From: Laura Gibbons <Laura.Gibbons@arun.gov.uk>
Sent: 01 December 2020 14:58
To: Planning.Responses <Planning.Responses@arun.gov.uk>
Cc: Michael Eastham <Michael.Eastham@arun.gov.uk>
Subject: A/179/20/RES- Land South of Water Lane Angmering

Engineers Comments Regarding Drainage/ Flood Risk

**WATER LANE, ANGMERING
BOX CULVERT
EXISTING
PLAN, SECTIONS & LEVELS**

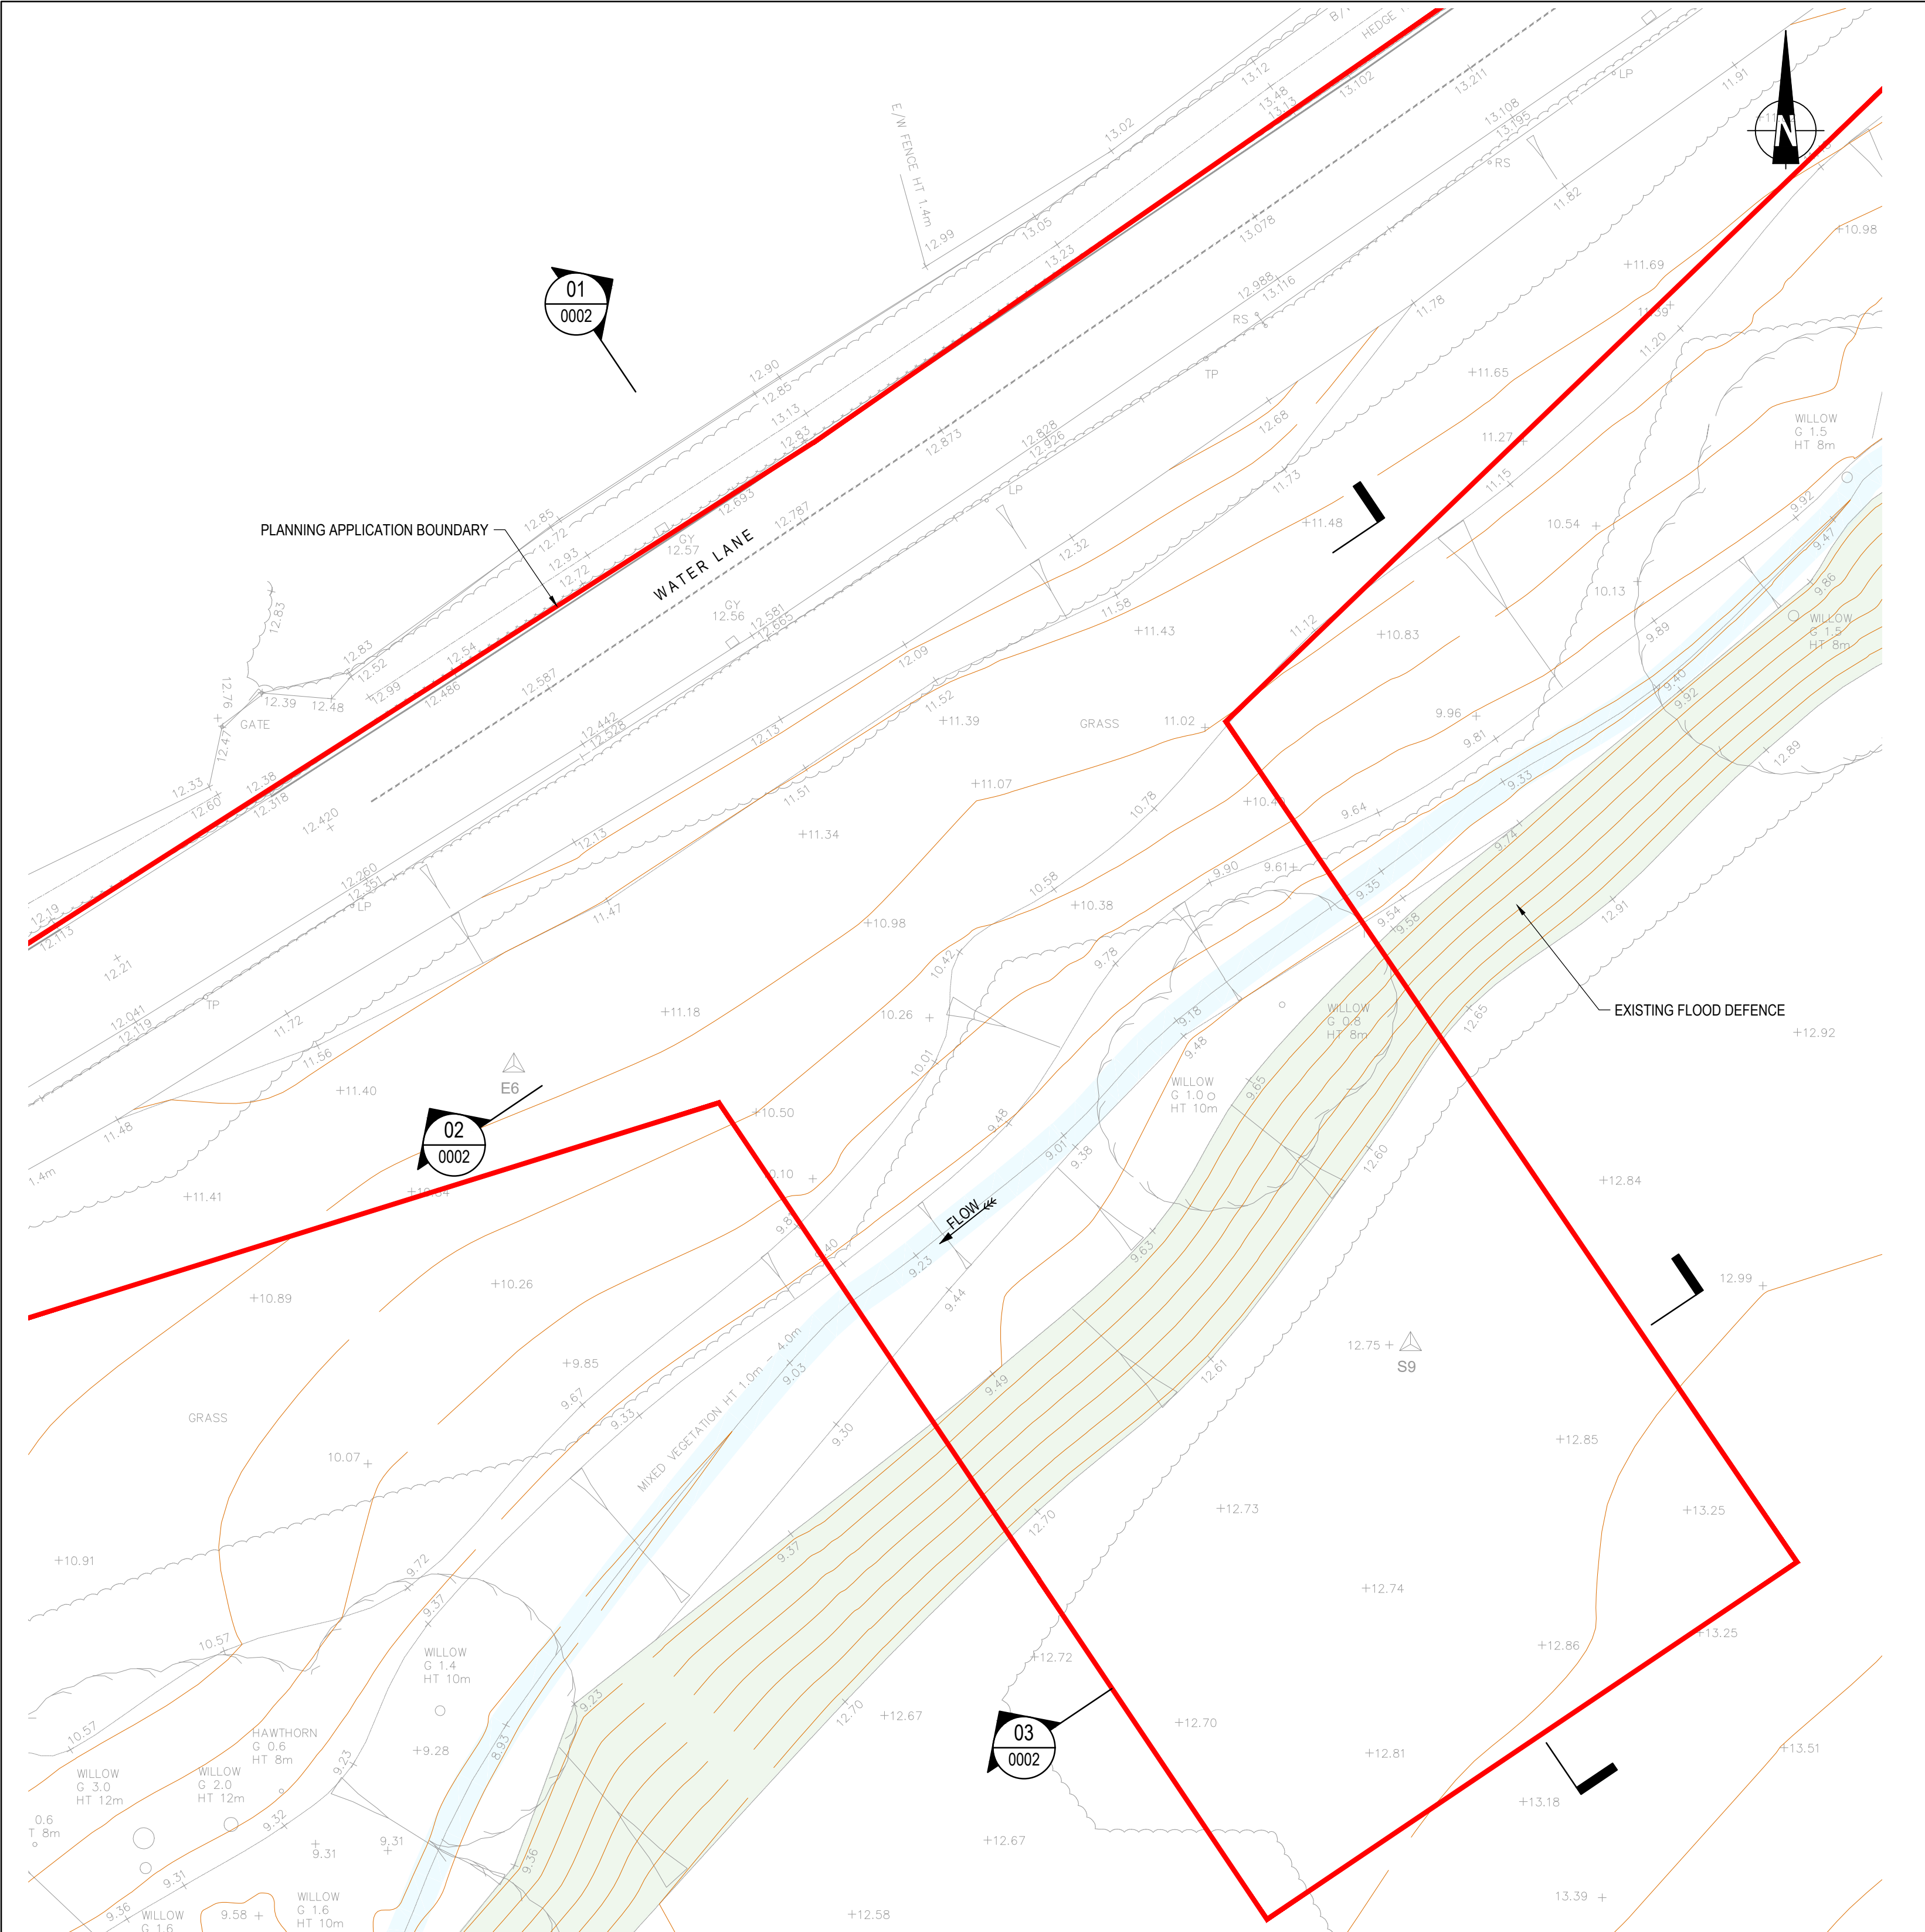
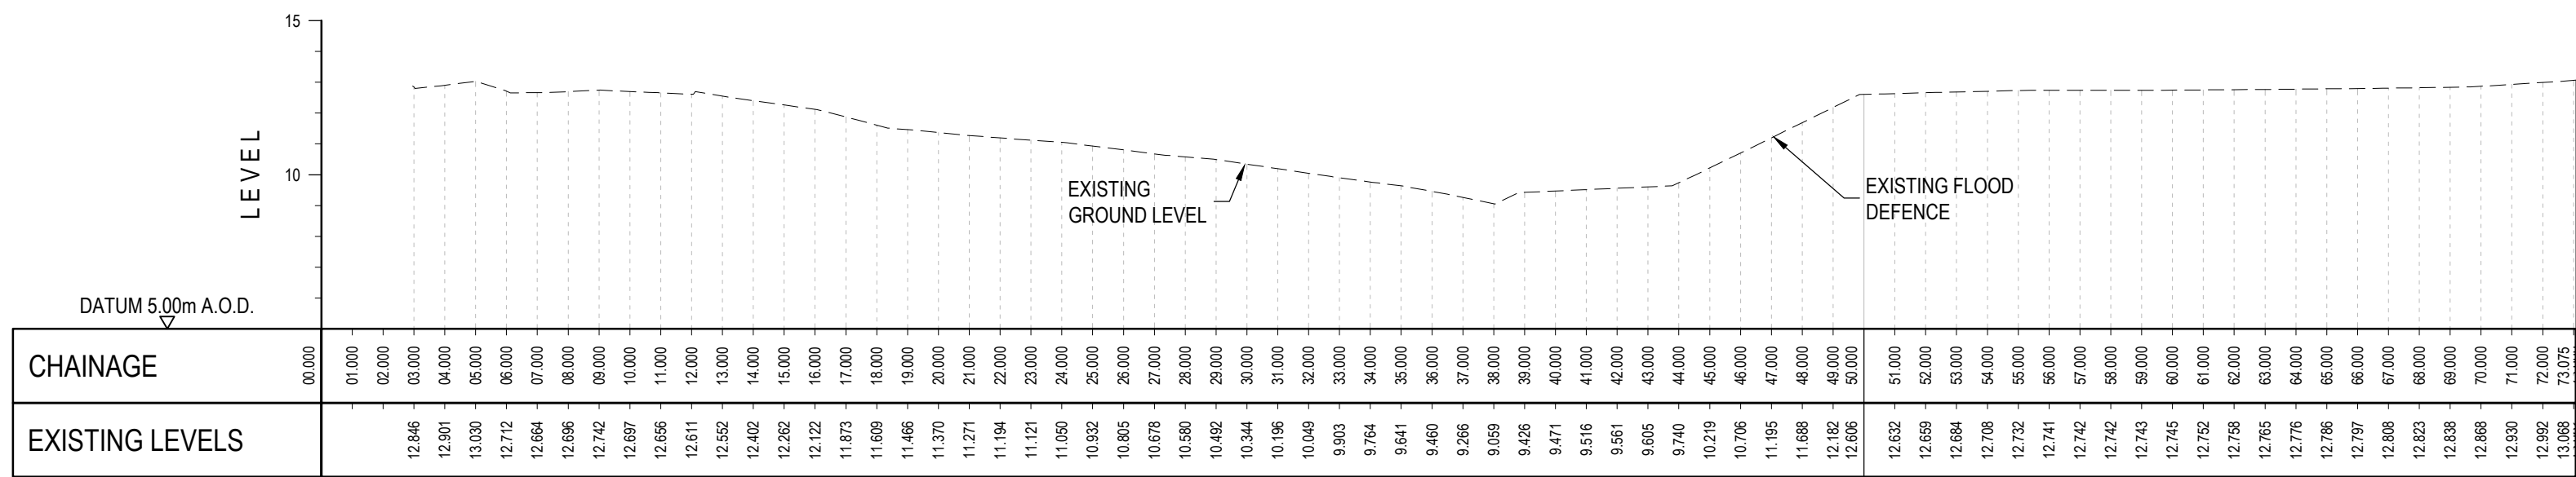
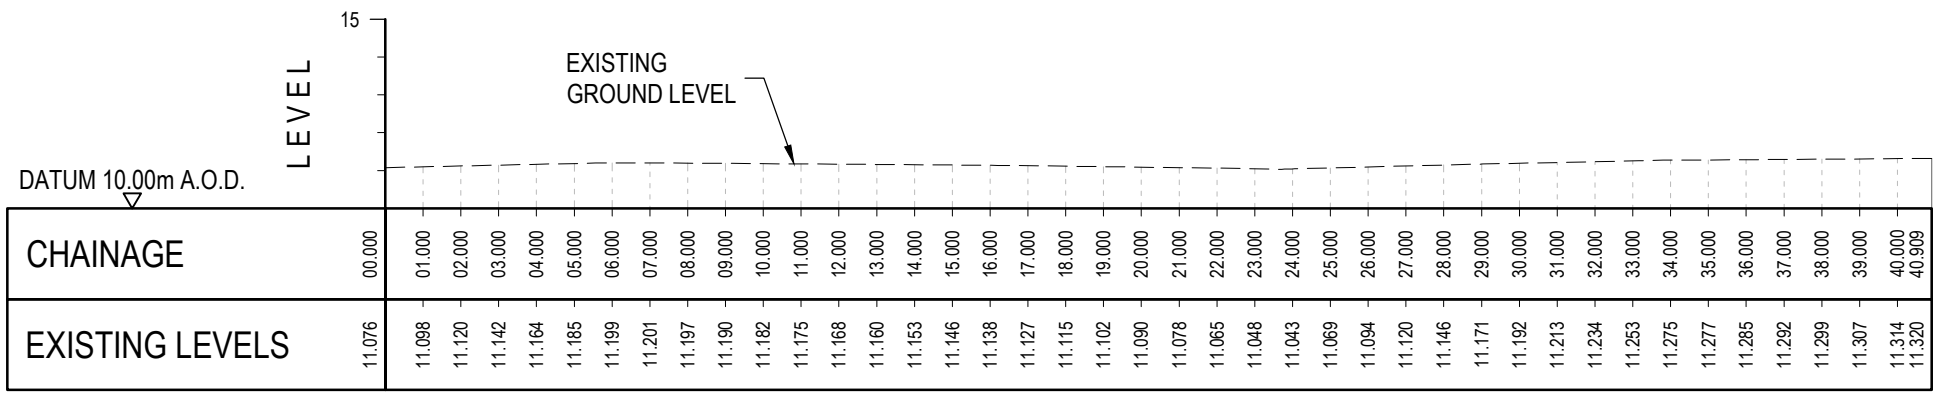
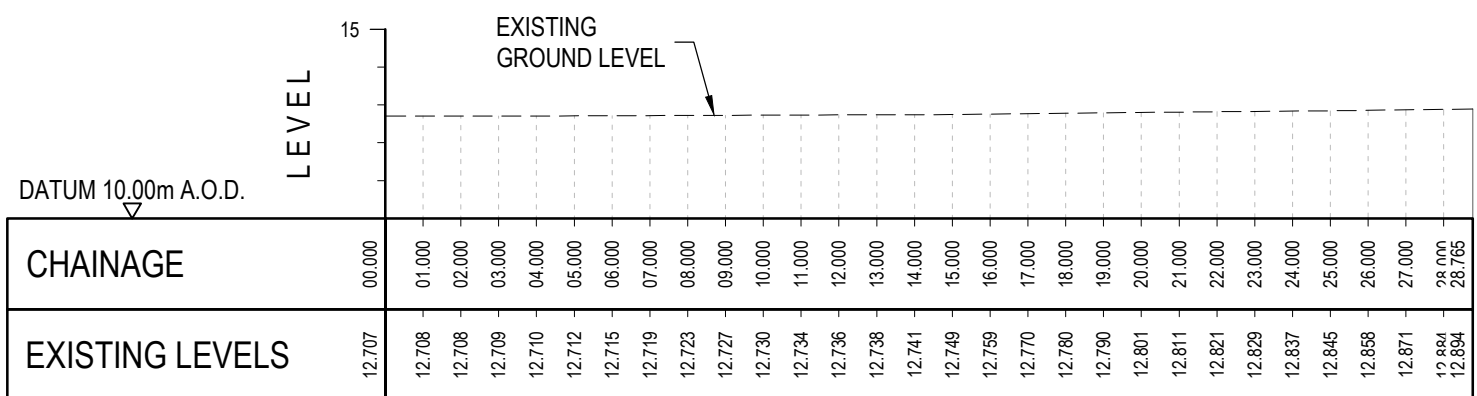
We support this scheme for a culvert as opposed to the previously proposed free-standing bridge. The proposal is consistent with the FRA for the Angmering Flood Alleviation Scheme.
